From: Contact Centre (CRM) <contact@ribblevalley.gov.uk>
Sent: 05 December 2023 11:02
To: Planning
Subject: Planning Application Comments - 3/2023/0886 FS-Case-567047301

Planning Application Reference No.: 3/2023/0886

Address of Development: 2 Bailey Cottages, Church Lane, Great Mitton. BB7 9PL

Drawing Title
PROPOSED SITE PLAN

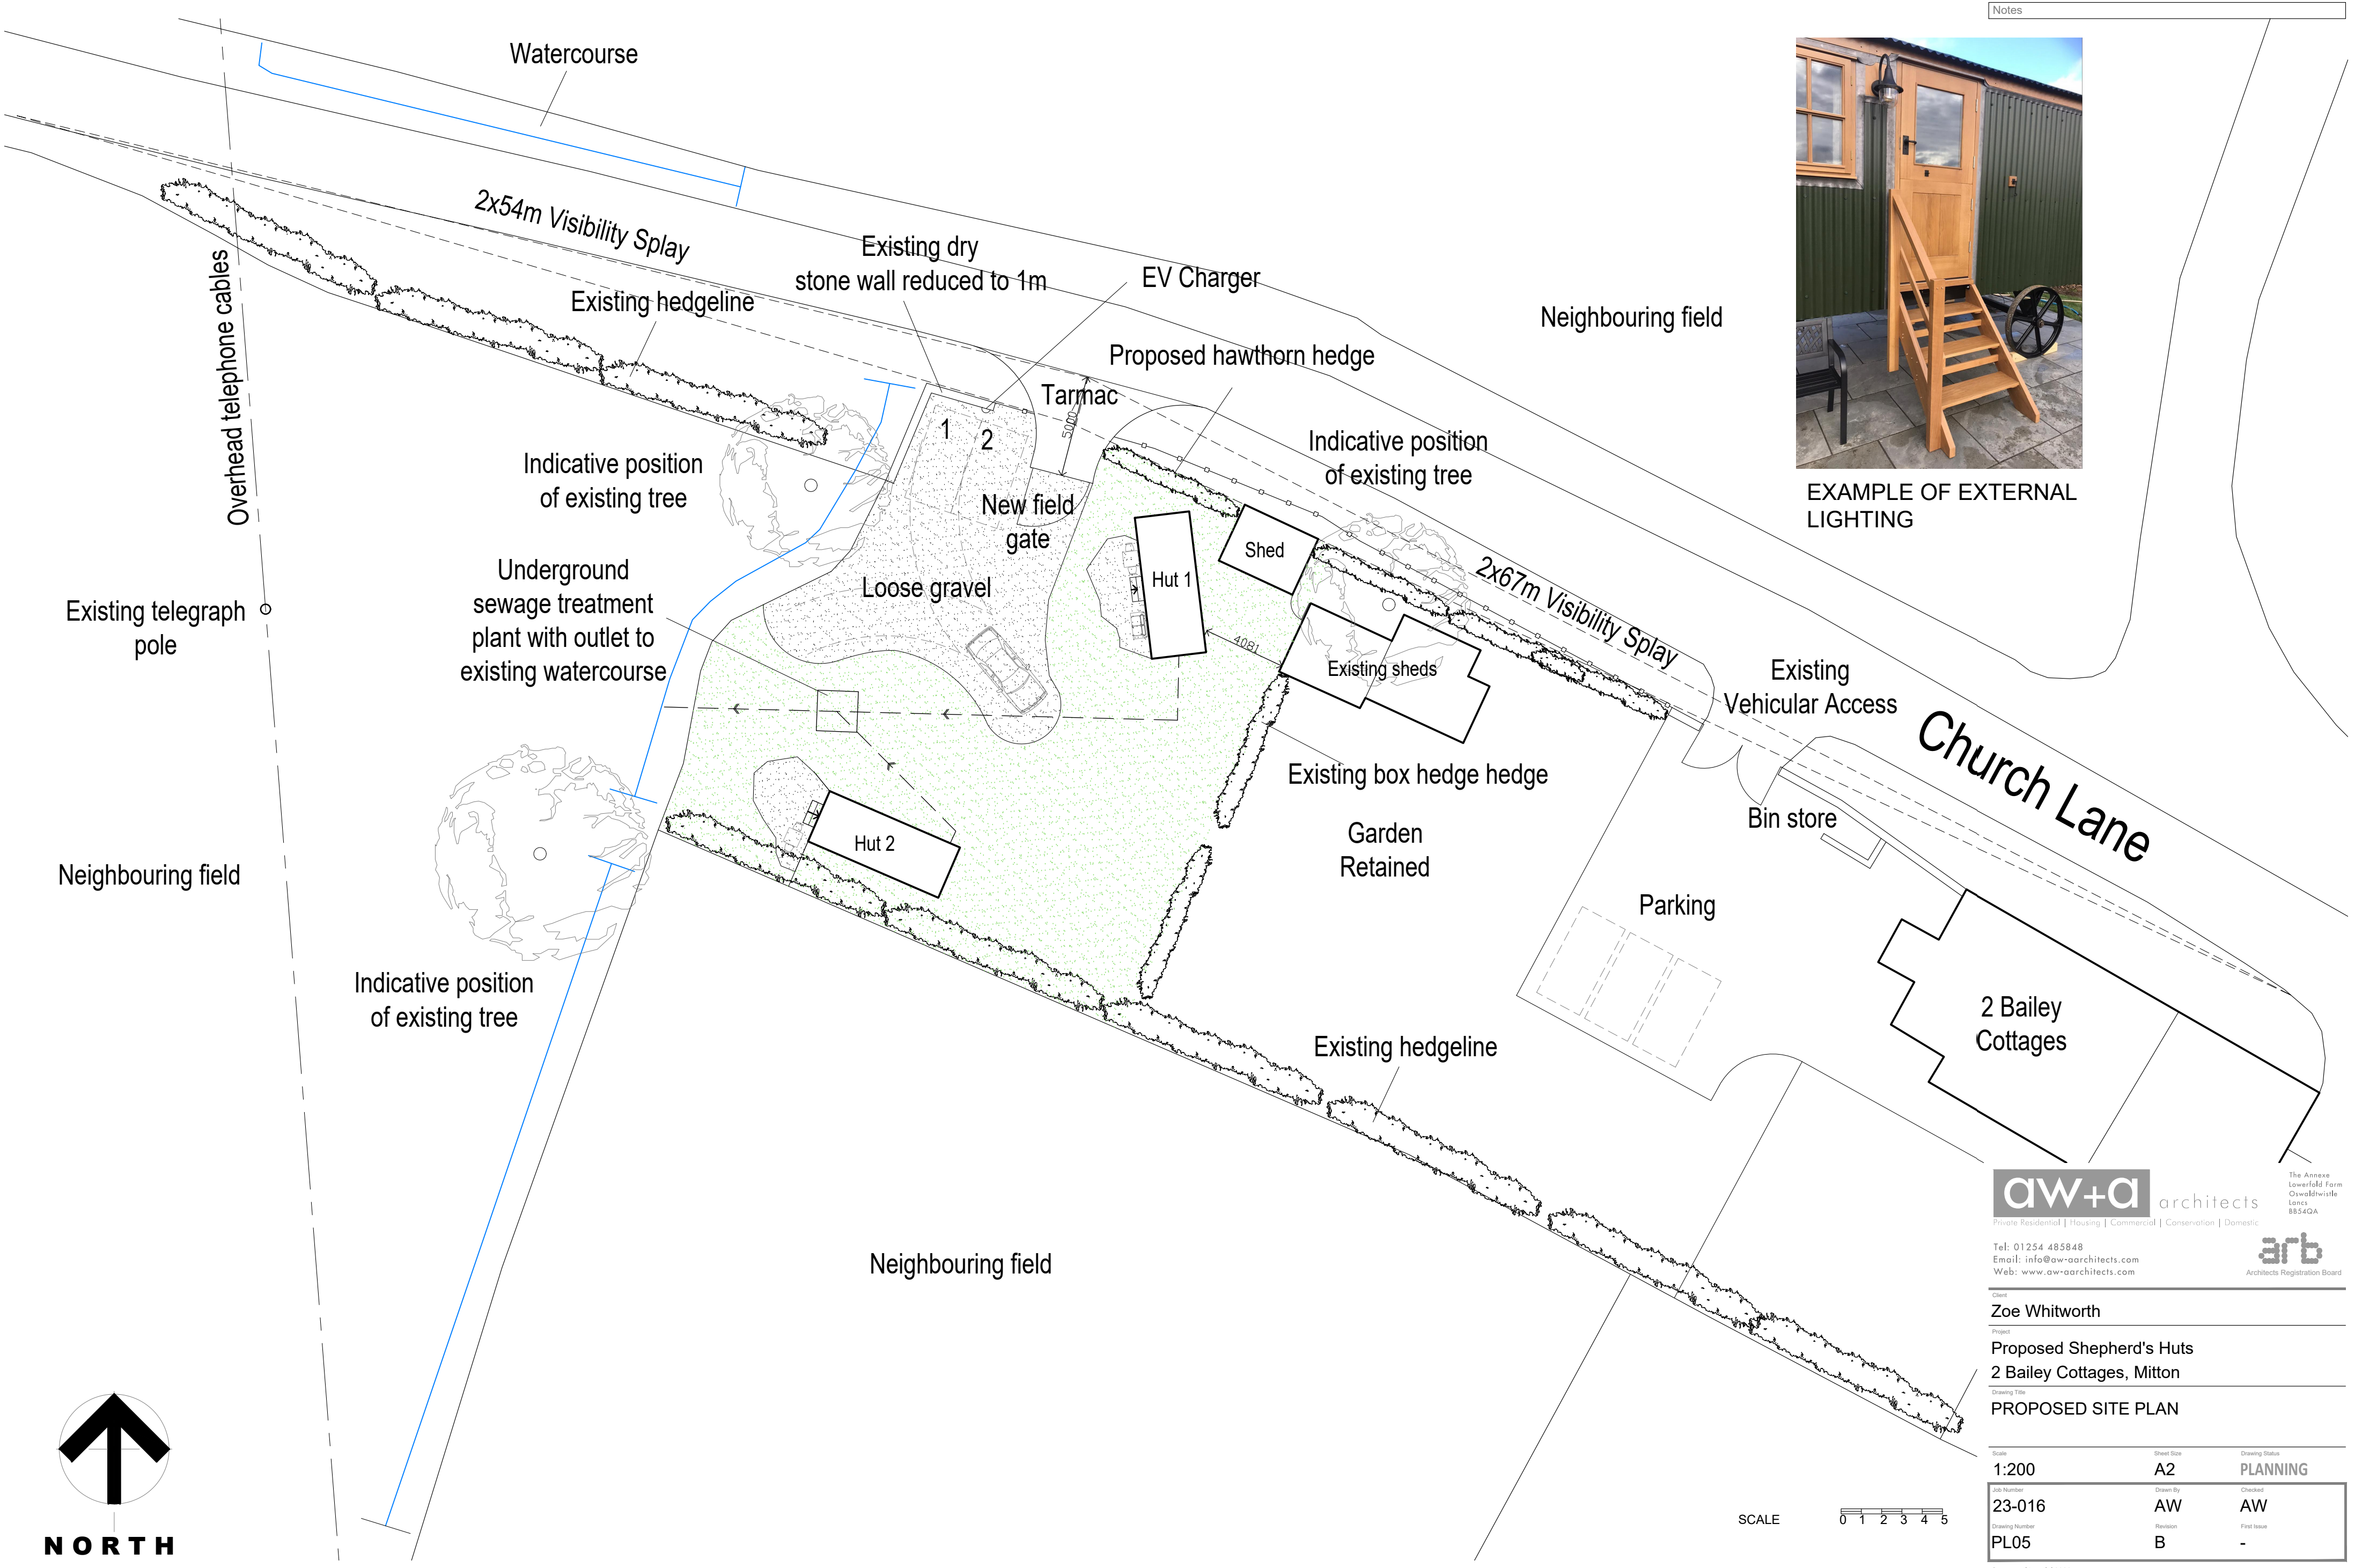
- 1.The proposal significantly alters the character of the area. The site has been used as private garden for the property for long time. Following recent removal of an established row of conifers along the garden edge the area is now very visible from the lane which would make this proposed change in character even more prominent than if the screening offered by the trees had been retained.

- 2.The field gate proposed to provide access and parking for two additional vehicles is equivalent to a new access. The gate has not been used to access the highway until the recent landscaping works. The main access would provide a safer solution and is clearly established as the main entrance to the property and garden.
